RE: Request for Information #2 for File No. SUB21-006, CAO21-004, SEP21-022 – Milestone Short Subdivision
7621 SE 22nd ST, Mercer Island, WA 98040; King County Tax Parcel # 531510-1846 **Applicant Response**

Re: Rand-Milestone Short Plat
7621 SE 22nd Street
Mercer Island, Washington
CAO 21-004

MILESTONE PRELIMINARY SHORT PLAT

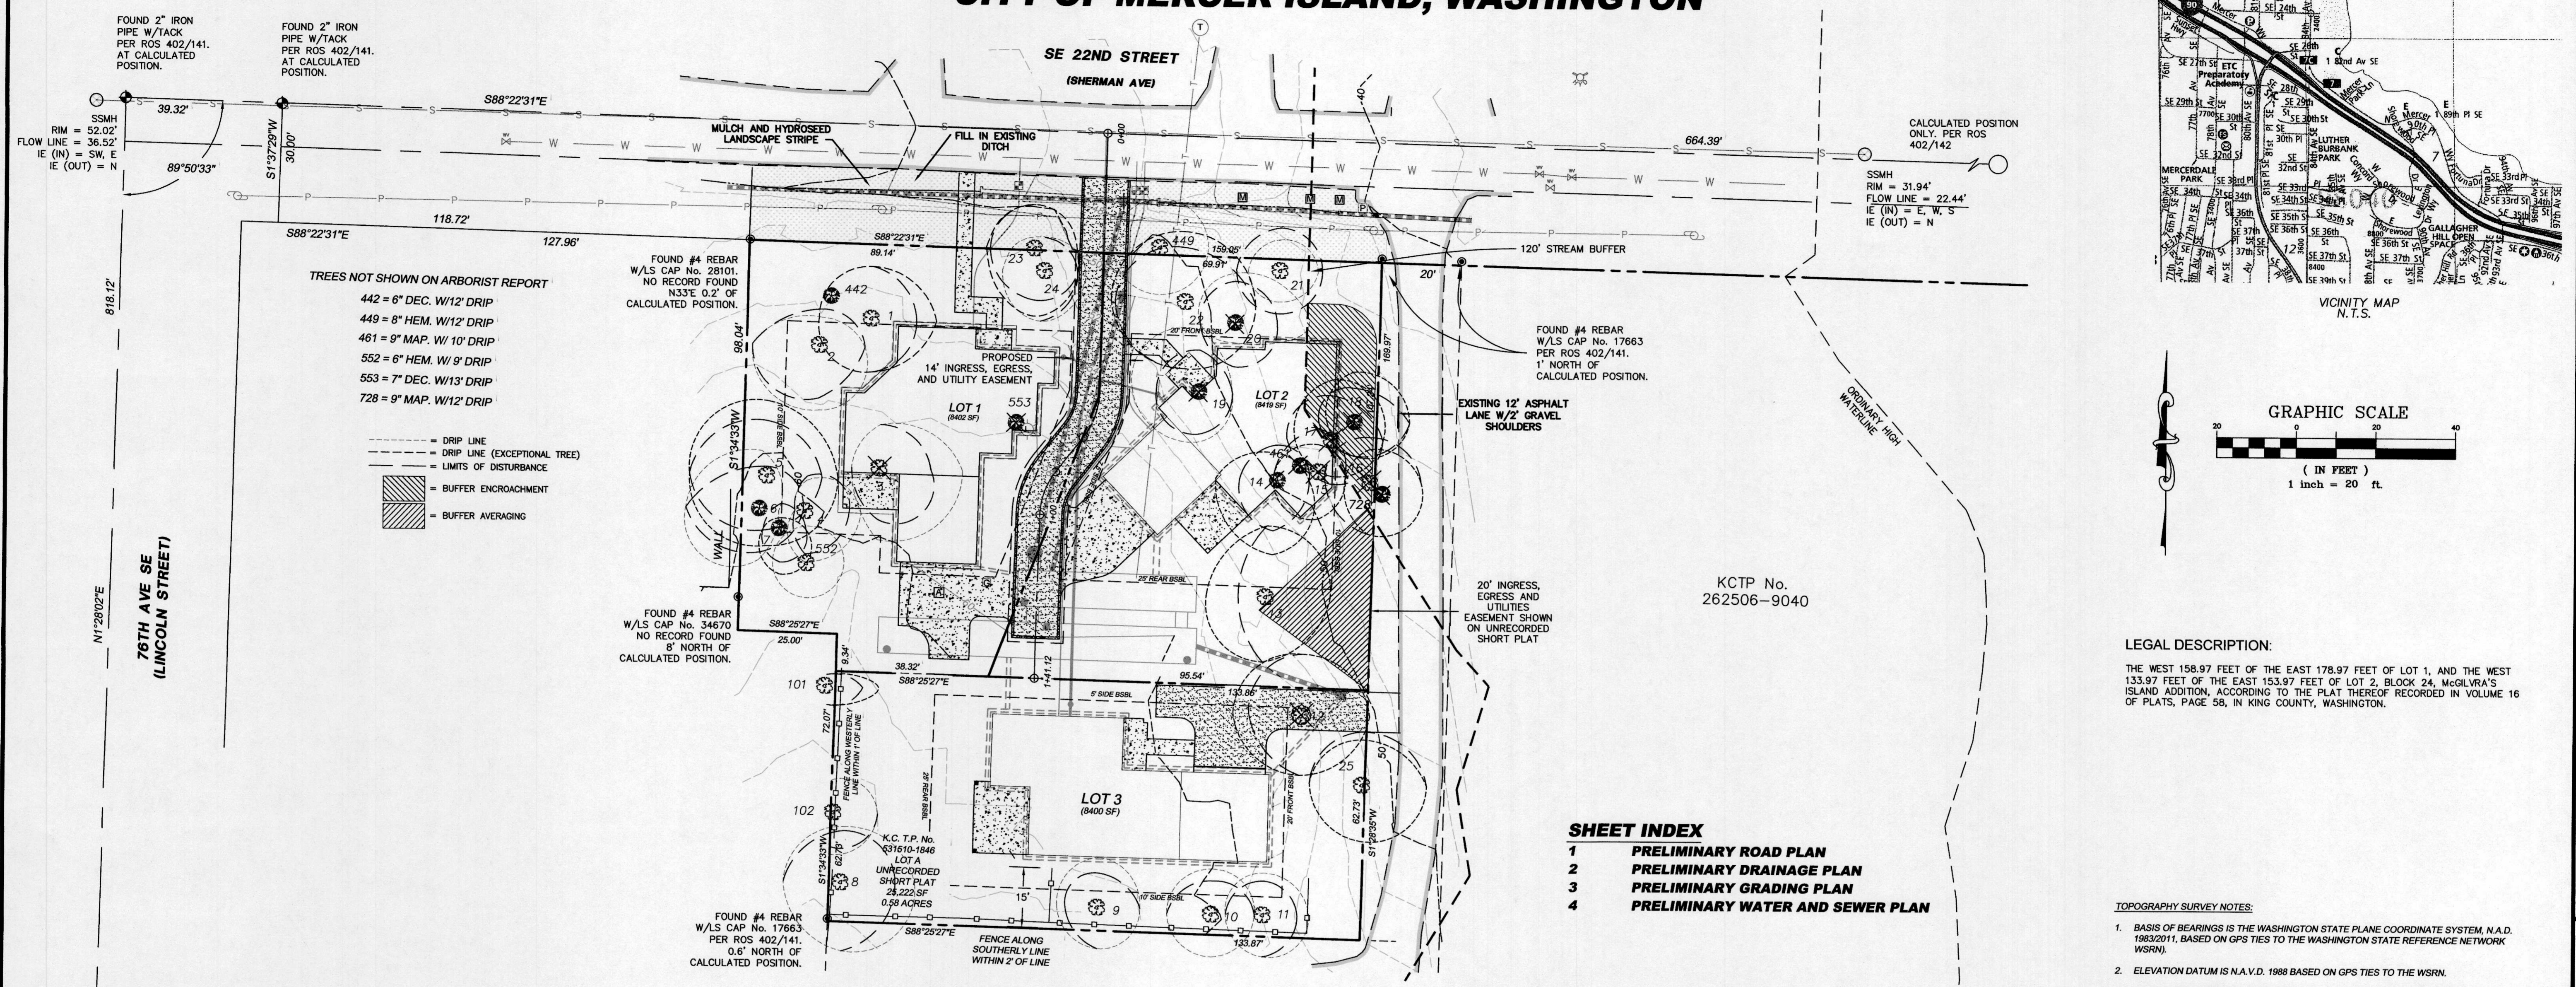
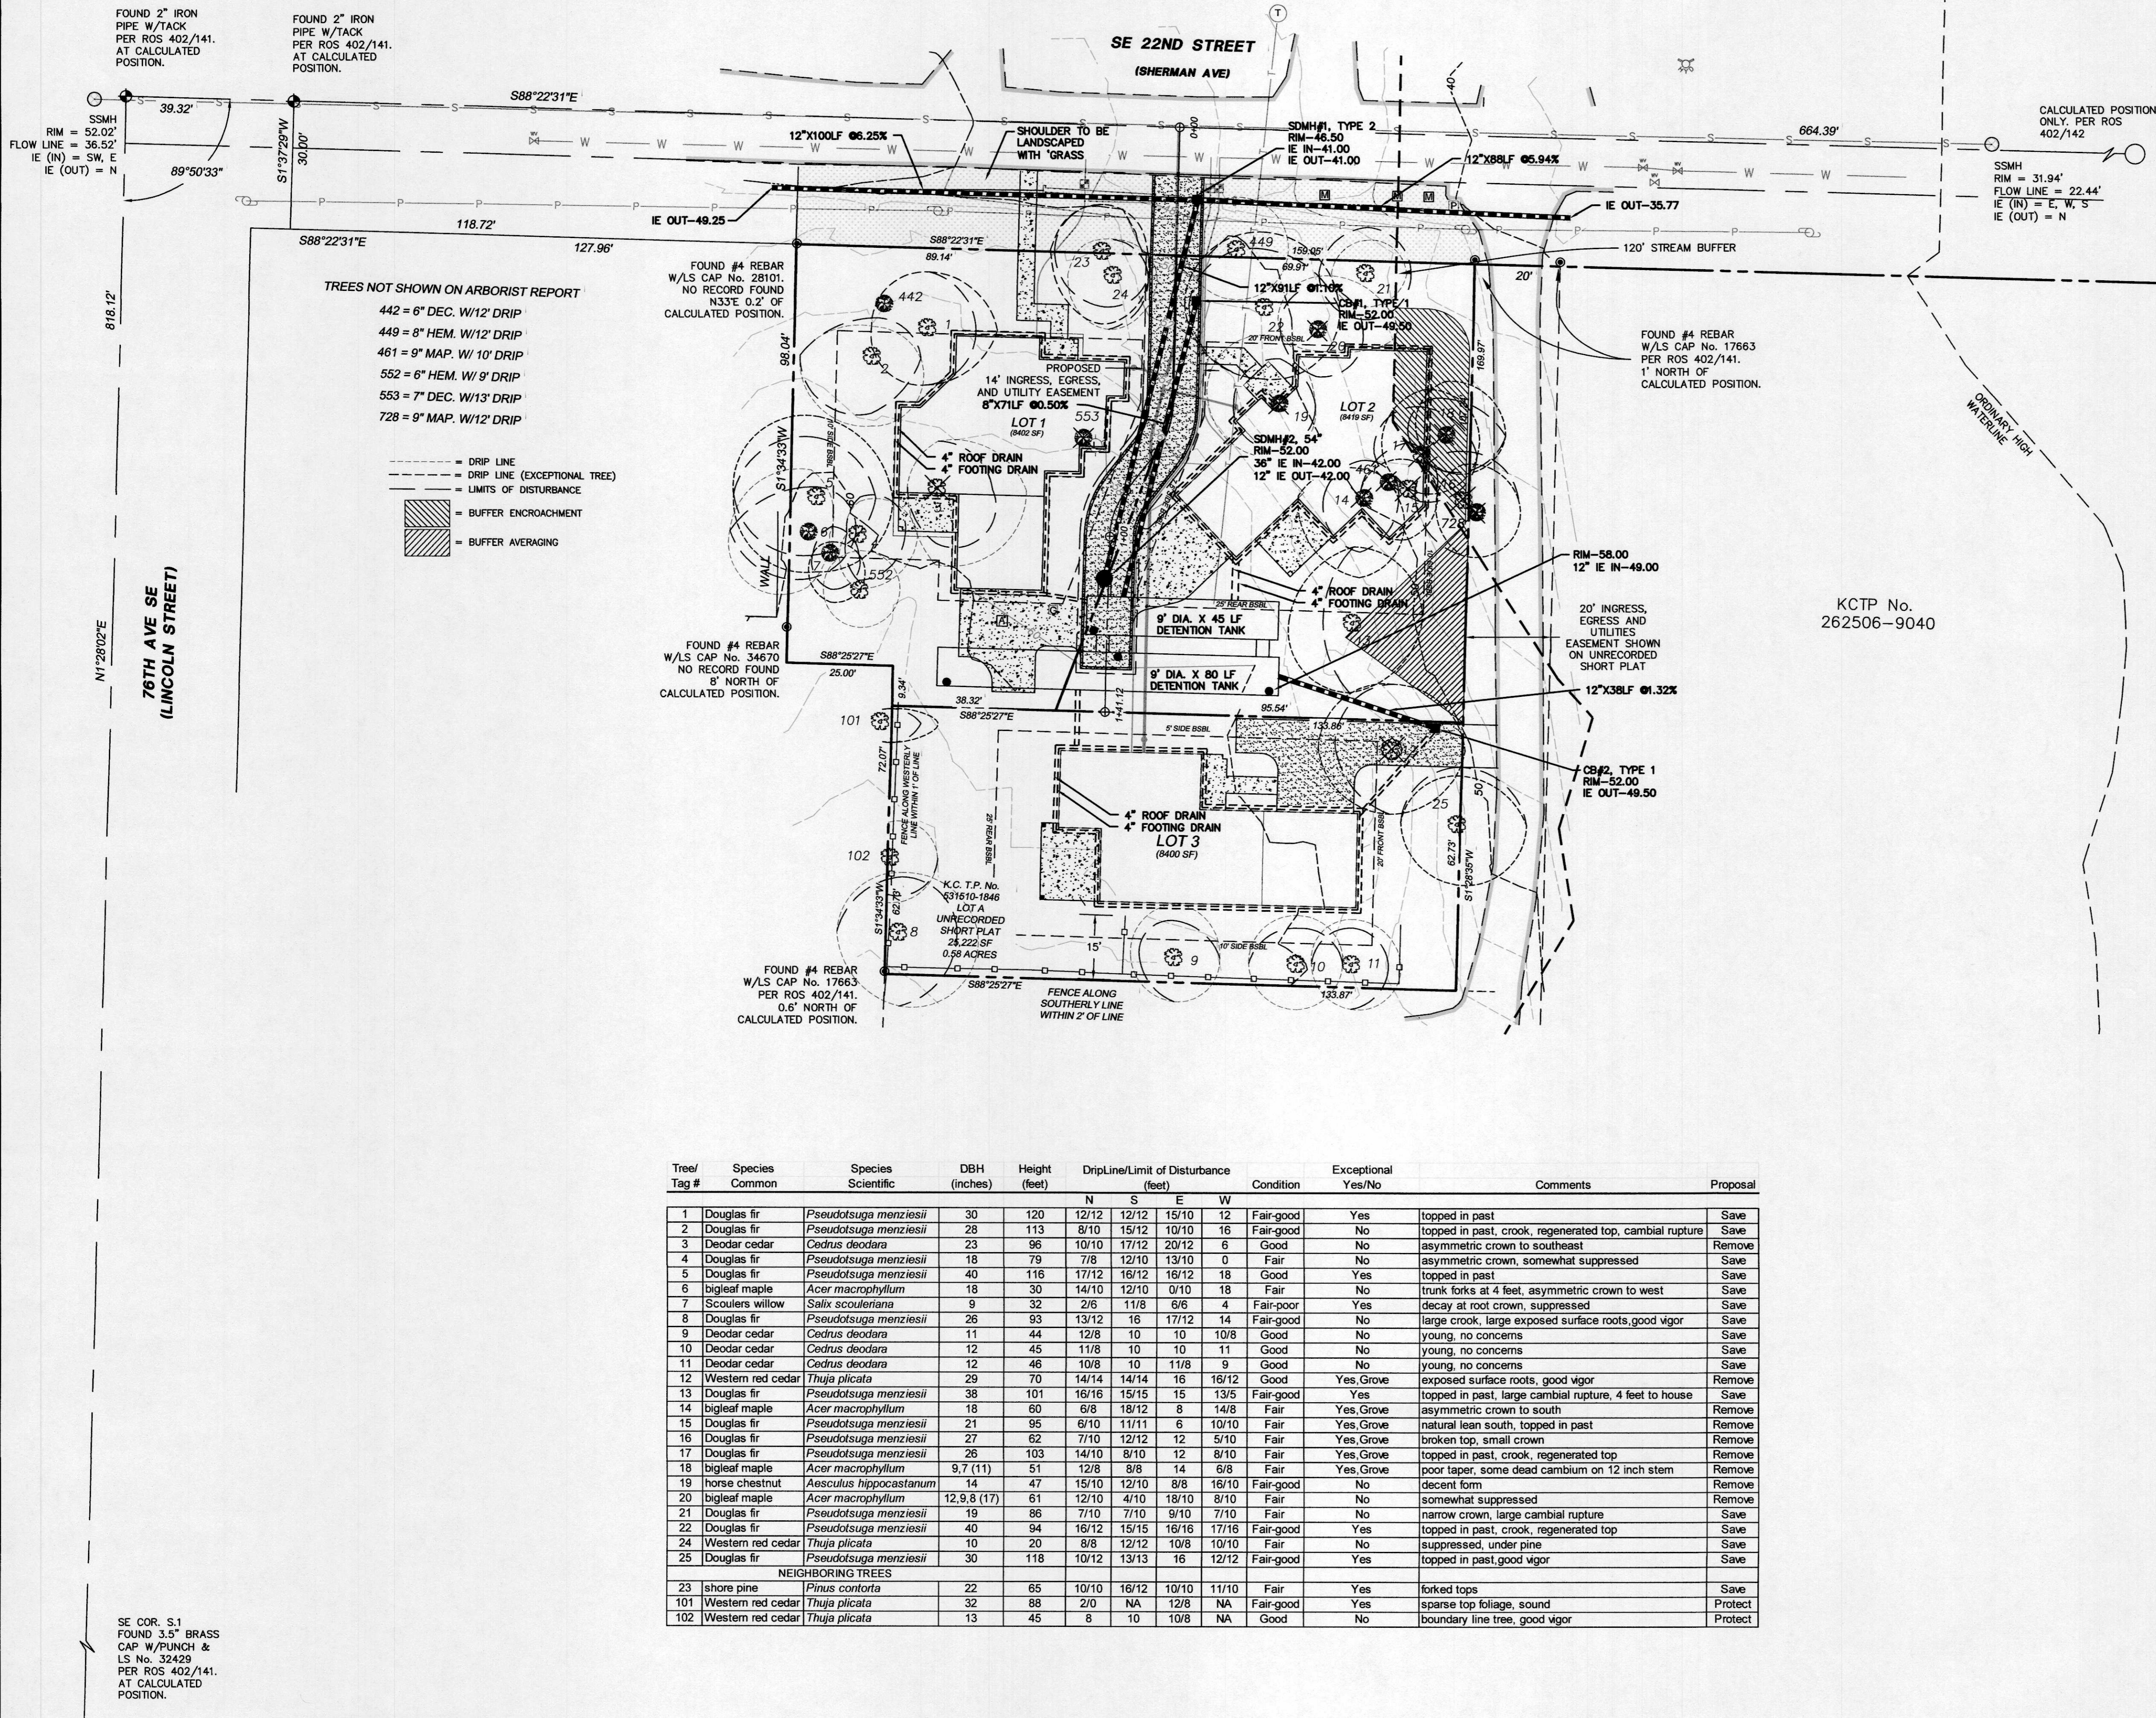
It appears that Lot 2 is located over the sloped portion (also designated landslide hazard) of the site. No final grading is provided in this area.

Comment 4: This code section (MICC 19.09.090) cannot be met without meeting code section MICC 19.07.160. Provide proposed final grades for the proposed lots. Provide information regarding proposed building excavation, e.g., will basement levels be involved? Provide an anticipated basement level elevation or finished floor elevations for at-grade structures for the proposed lots.

Adequate grading information should be provided for Lot 2 so that the geotechnical engineer can assess potential slope stability impacts and provide design mitigation recommendations.

# RAND-MILESTONE 3 LOT PRELIMINARY SHORT PLAT

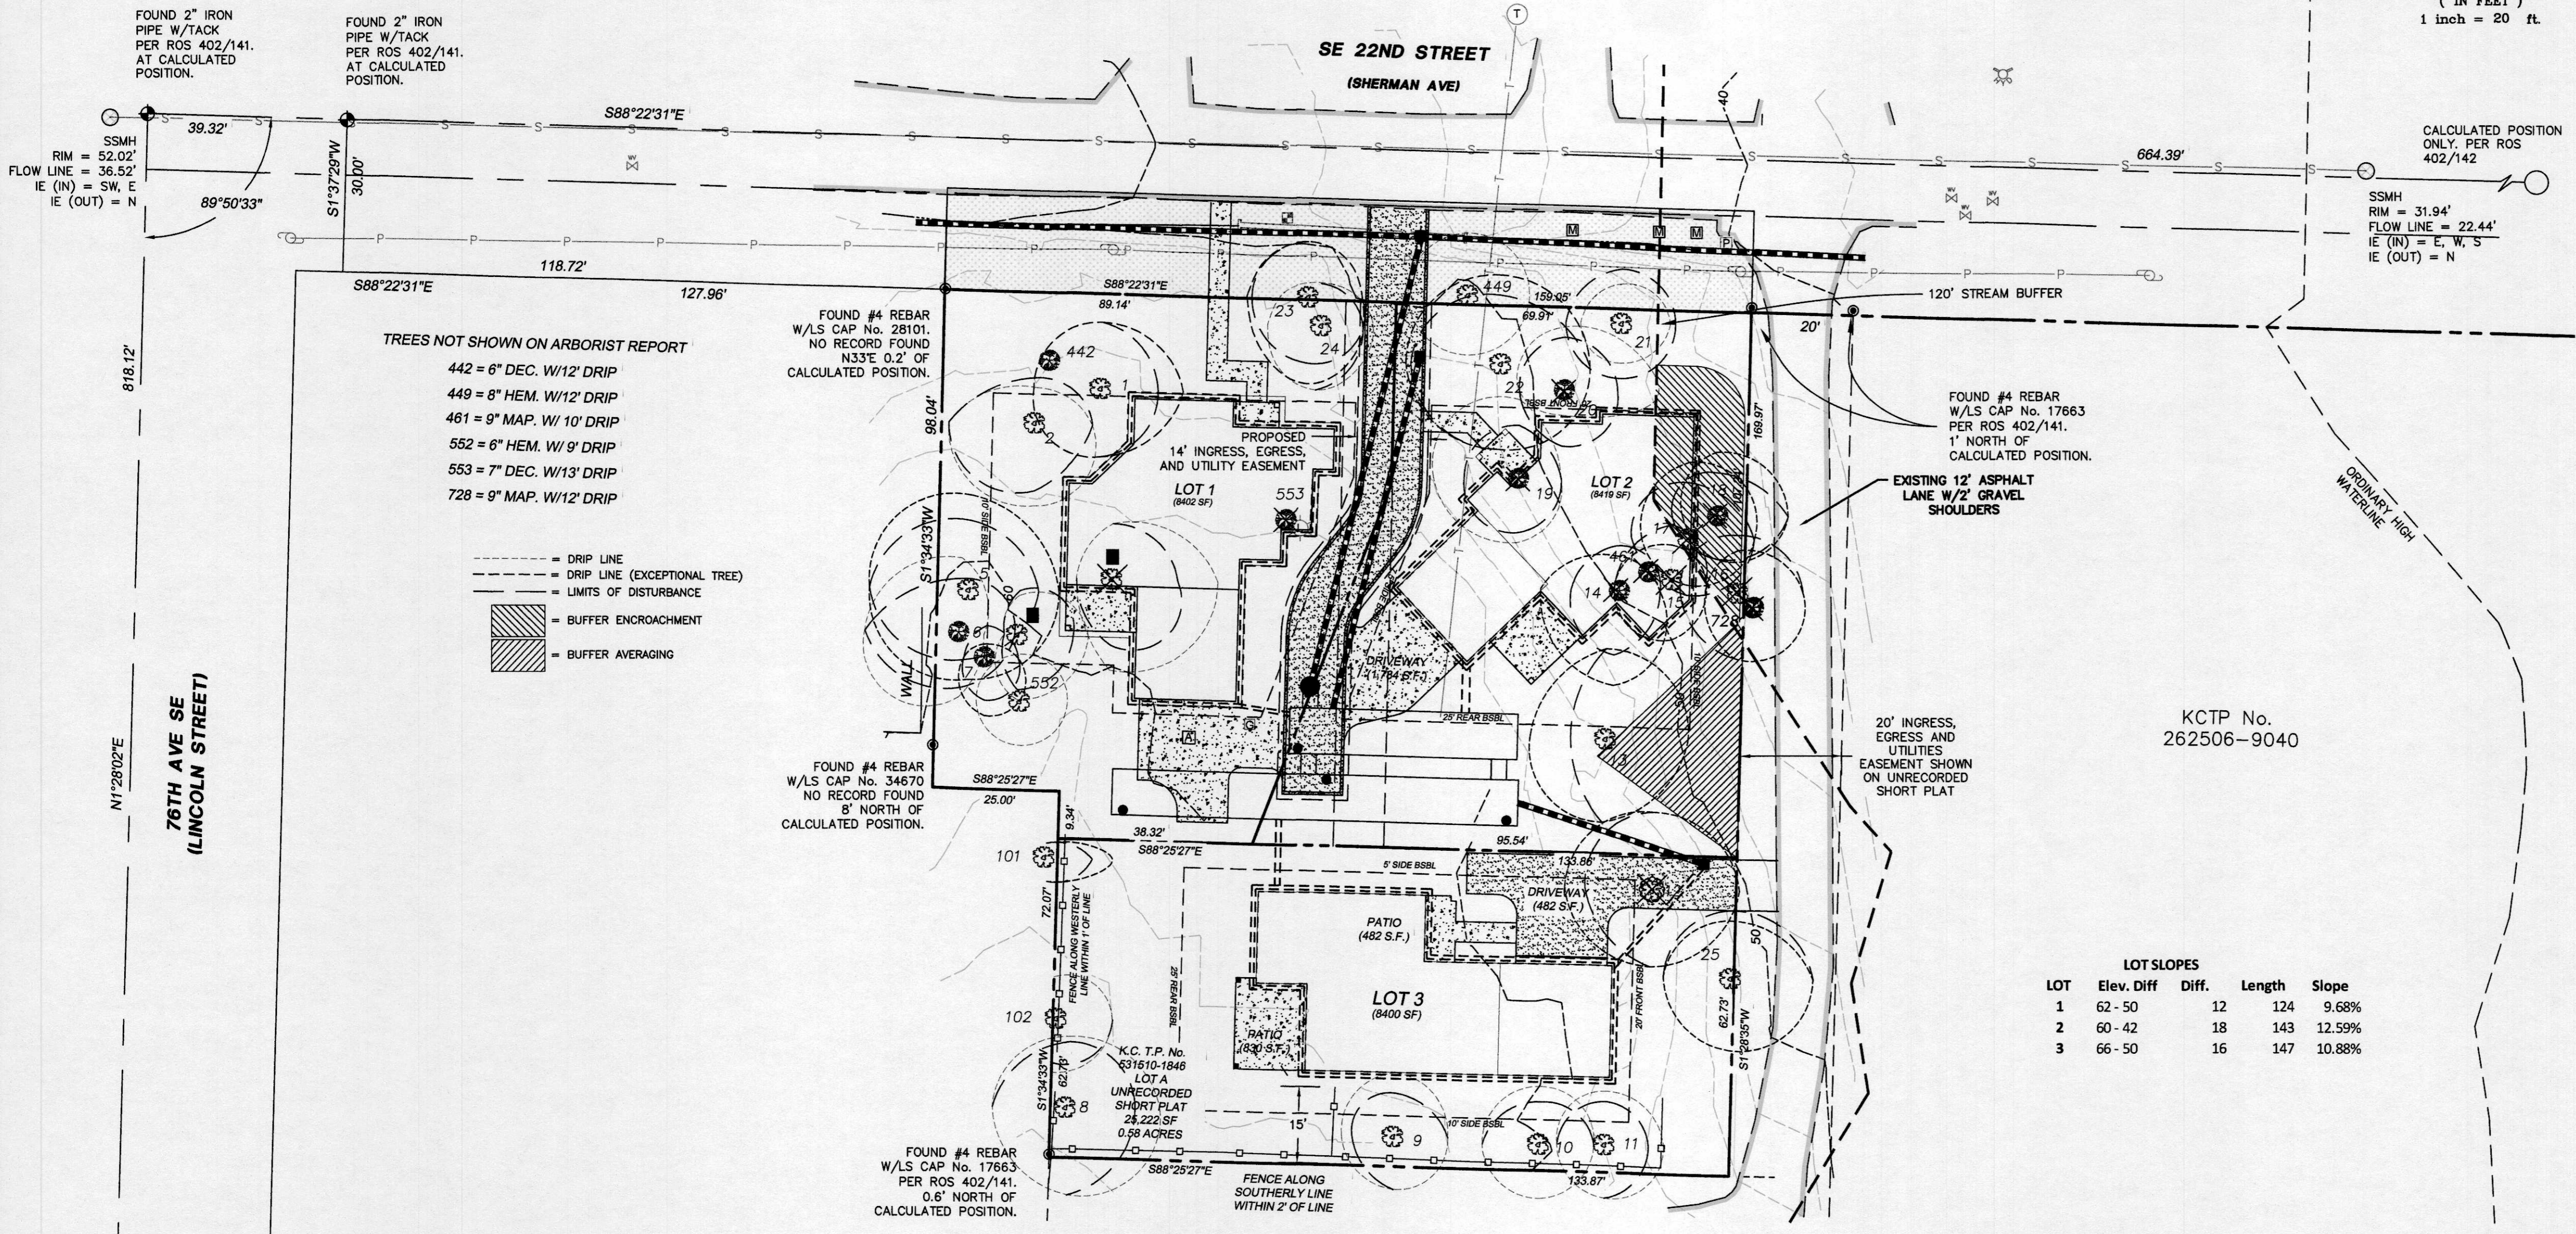
1. Please show the new lot lines with distances and bearings, as well as legal descriptions for all proposed easements and new parcels. **Per email from Ruji Ding, applicant has added distances and bearings for the proposed easements to Sheet 6 of the Civil Plan**
